KIRKLEES METROPOLITAN COUNCIL INVESTMENT & REGENERATION SERVICE

DELEGATED DECISION TO DETERMINE PLANNING APPLICATIONS

Reference No:	2022/62/90937/E
Site Address:	48, Woodburn Avenue, Earlsheaton, Dewsbury, WF12 8LJ
Description:	Erection of single storey rear extension and side dormer extension
Recommending Officer:	Elenya Jackson

REVISIONS:

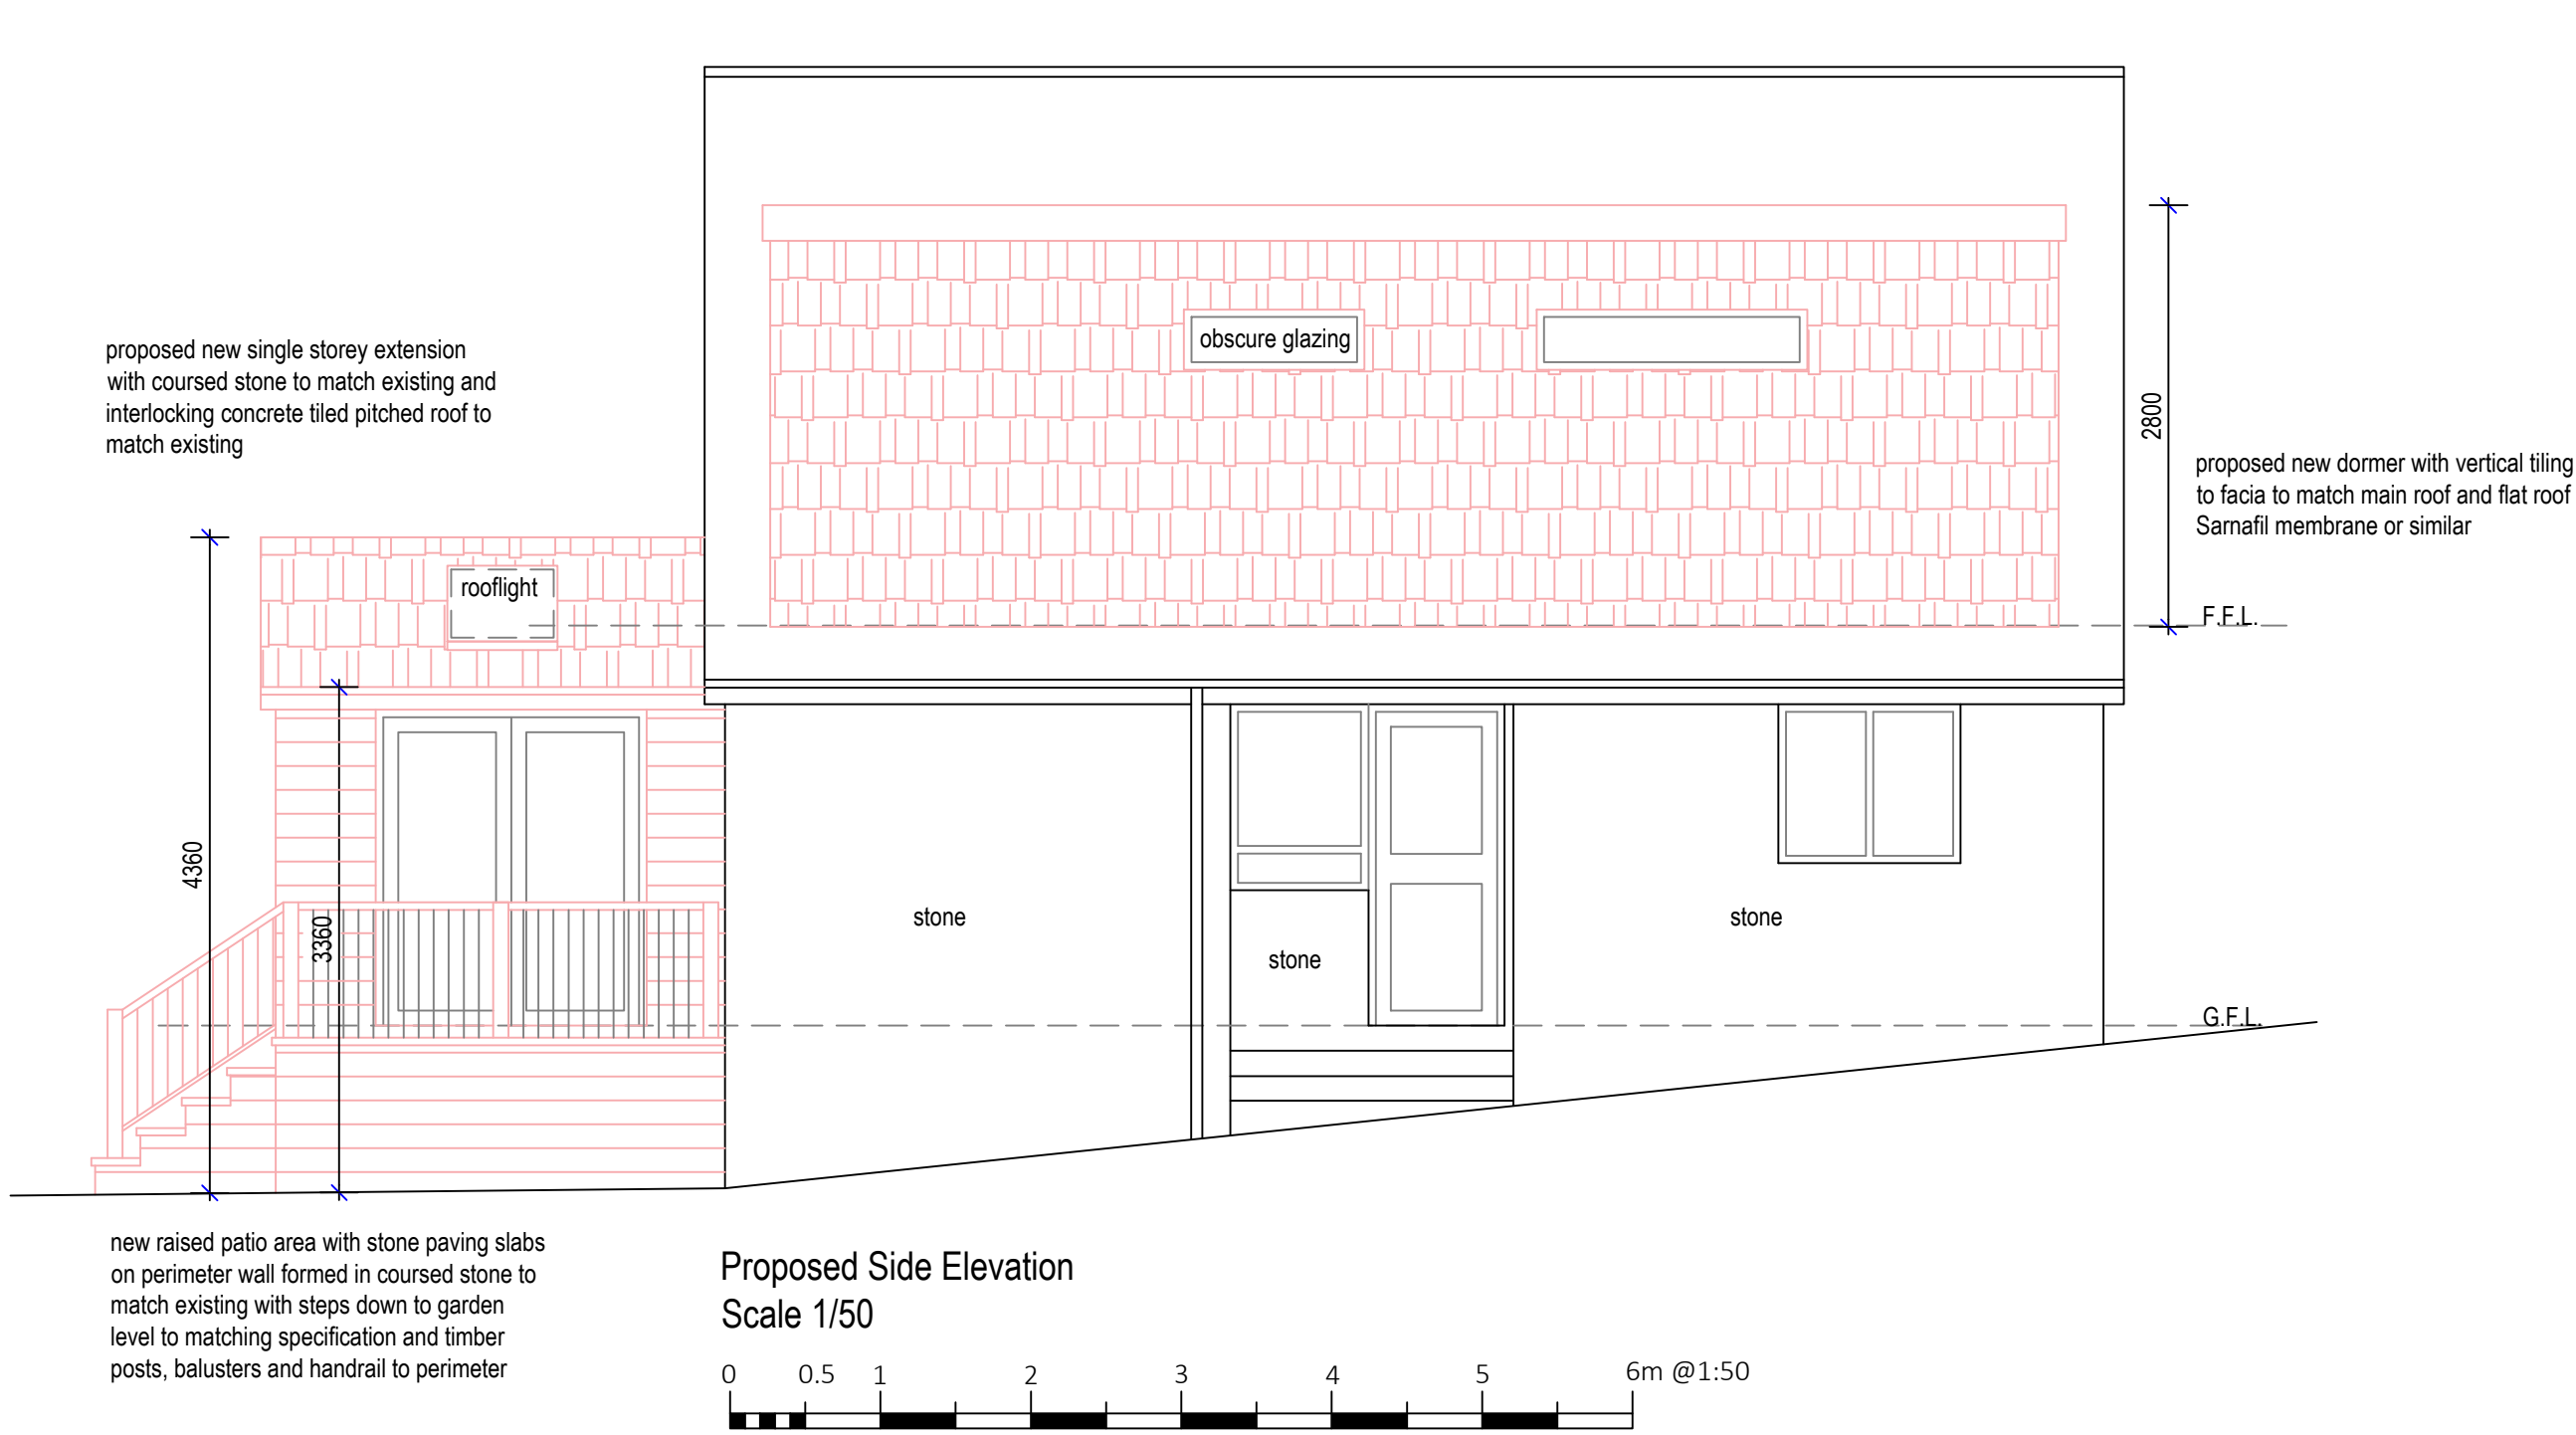
Overlooking: There is currently a fence between the gardens of the two properties and the driveway for both dwellings. The proposal would feature three side facing windows. One would be situated in the single storey rear extension and two would be situated in the dormer. It is considered that as the extension would be raised, the boundary treatment would not provide sufficient screening and a condition would be required for a 1.8m screen to be erected prior to first use to prevent the occupiers of no.48 being able to look into the private amenity space of no.50.

The dormer would feature two side facing windows, one of these would serve a bedroom. Due the design and positioning it is considered to mitigate any potential loss of privacy to adjoining occupants. It is not considered necessary to request this is obscurely glazed due to its height and distance from the neighbouring dwelling.

The bathroom window is shown to be obscurely glazed which is acceptable. Overshadowing/loss of light/overbearing: due to the scale of the proposal, there would be sufficient distance between the proposal and no.50 to not raise any significant issues regarding overshadowing/loss of light/overbearing.

4. The development shall not be occupied until the bathroom window in the north elevation of the dormer hereby approved have been obscure glazed. The obscure glazing shall thereafter be retained for the life of the development.

5. The development shall not be occupied until a 1.8m boundary screen has been erected on the northern elevation of the proposal. The screen shall thereafter be retained for the life of the development.
